**Planning Department
Transportation Development Services**

**Re: Aztec Special Education Facility
2611 Eubank Blvd., NE
Traffic Circulation Layout
Engineer's/Architect's Stamp dated 7-27-15 (H20-D33)**

AS-101

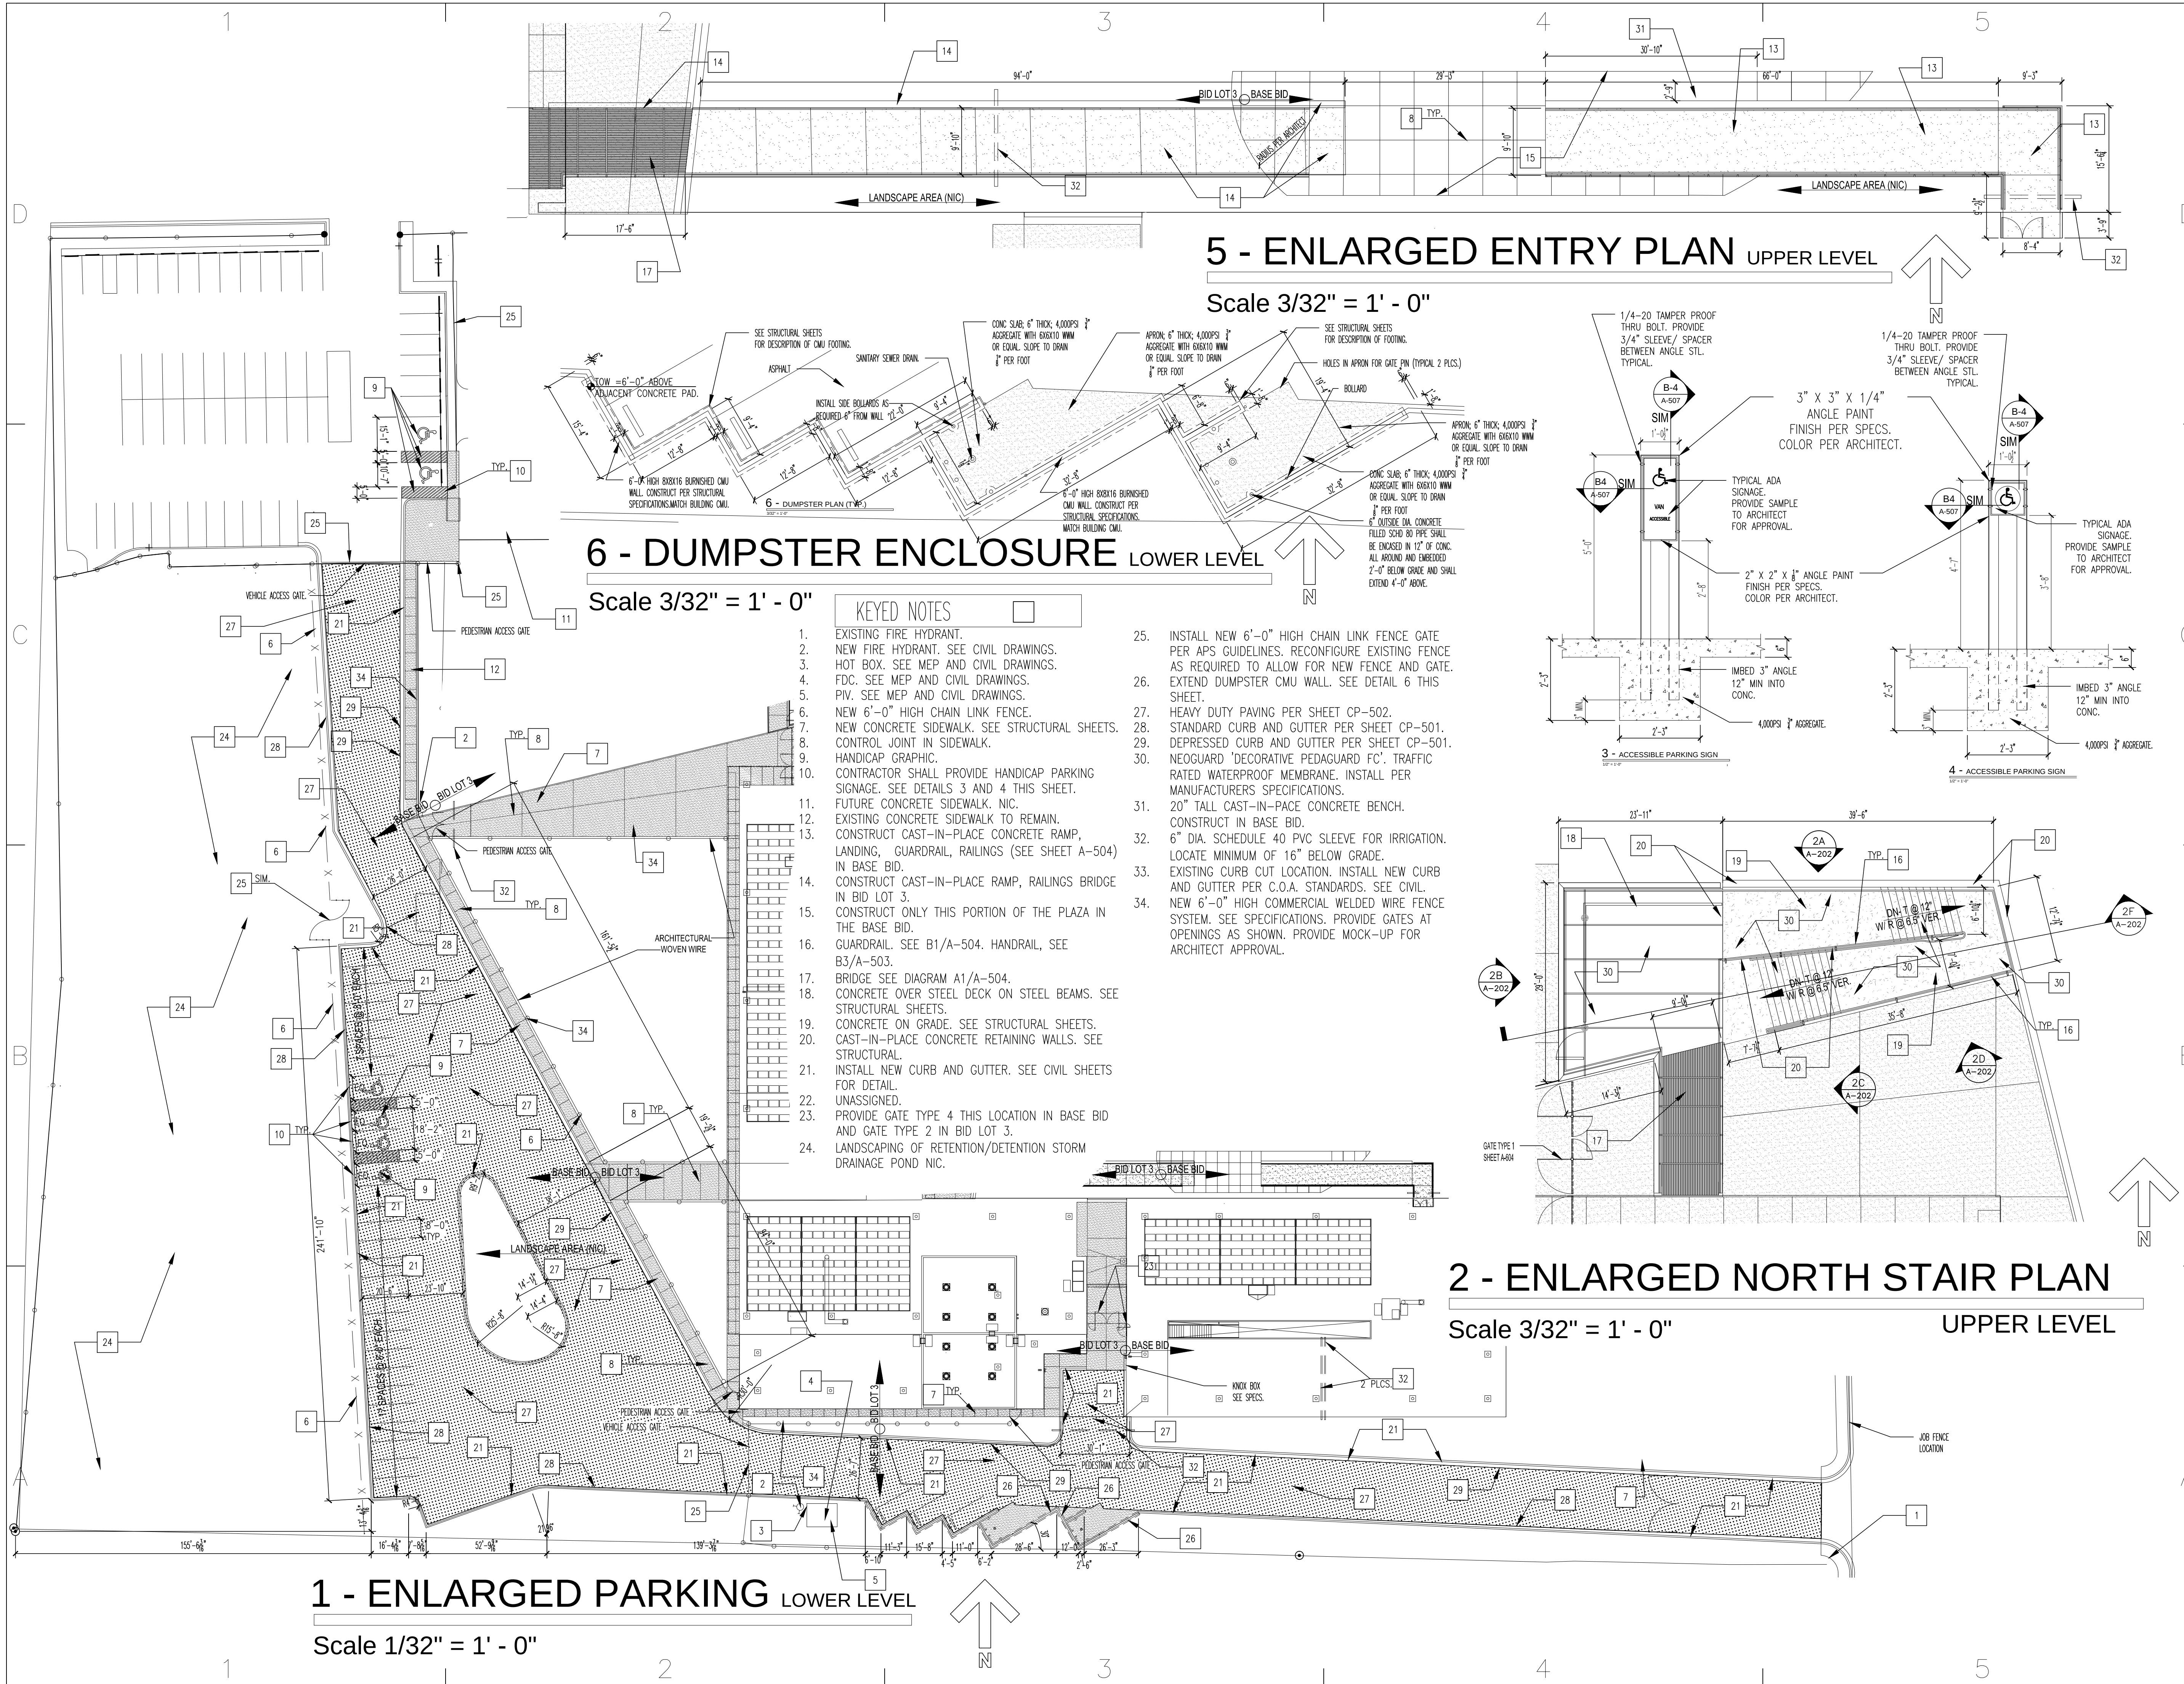
6. Please list the width and length for all parking spaces.
7. Label the compact parking spaces by placing the words "**COMPACT**" on the pavement of each space. Per review of drawing, AS-100 details 15 ft. parking spaces, which are considered compact spaces. However, on AS-101 the parking spaces are detailed as 20.6 ft. in length. Please clarify width and length off all parking spaces.
